Subject: Consultation Response 2021/90800 Hinchcliffe Mill

RE: 2021/90800 - Redevelopment and change of use of former mill site to form 19 residential units (within a Conservation Area) @ Hinchcliffe Mill, Water Street, Holmbridge, Holmfirth, HD9 2NX

Ground Floor Plan 1:100

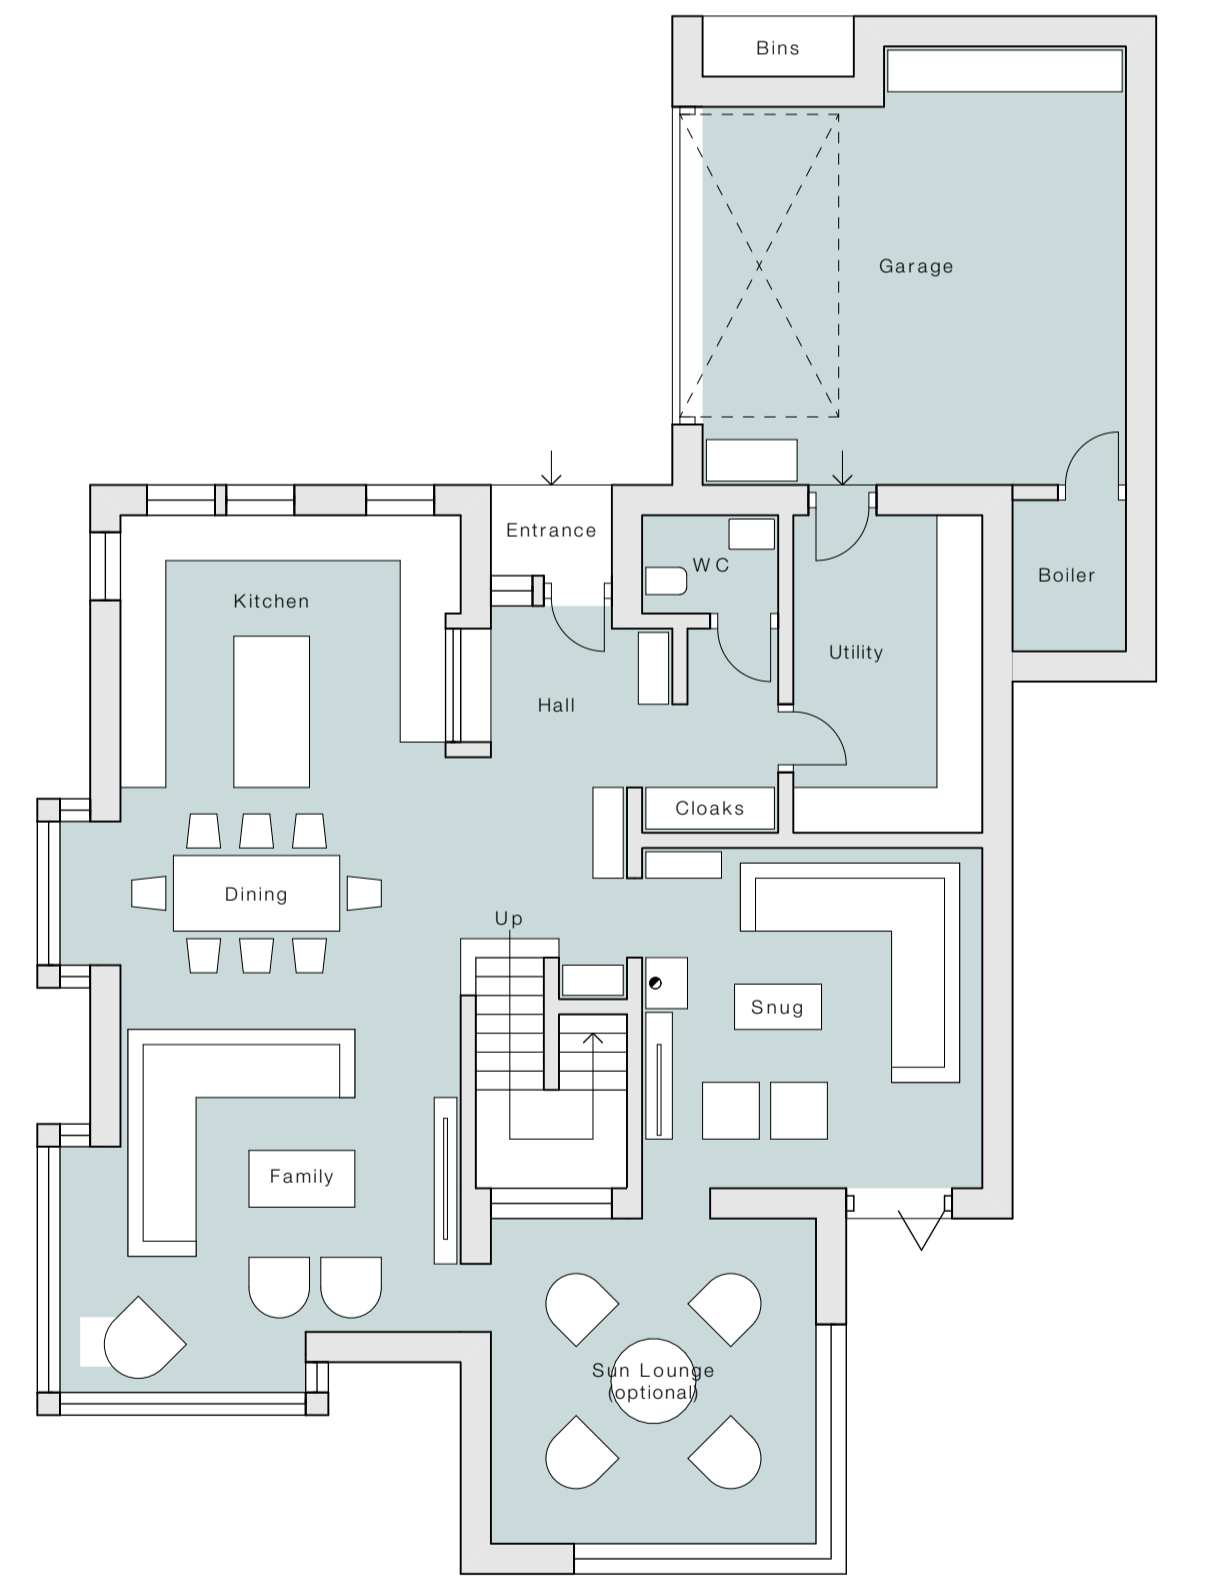
The structural engineers report states "The ground bearing slab is likely to require replacement to facilitate the proposed conversion to address damp ingress and thermal aspects."

Therefore I believe a structural watching brief is warranted on the ground floor of the northern part of the mill. This is to elucidate questions relating to the means of generating and distributing power within the mill including

both the original water wheel and later steam engine installations. The mill originally had a fulling mill on its lower ground floor and evidence of this activity may also survive below the present slab. Information on the flood of 1852 may also be revealed in this area.

This work can be secured as a condition of any grant of planning awarded by Kirklees District Council. Either of the following conditions would achieve the necessary record:

“No development to take place within the area indicated until the applicant, or their agents or successors in title, has secured the implementation of a programme of archaeological and architectural recording. This recording must be carried out by an appropriately qualified and experienced archaeological consultant or organisation, in accordance with a written scheme of investigation which has been submitted by the applicant and approved in writing by the Local Planning Authority.”
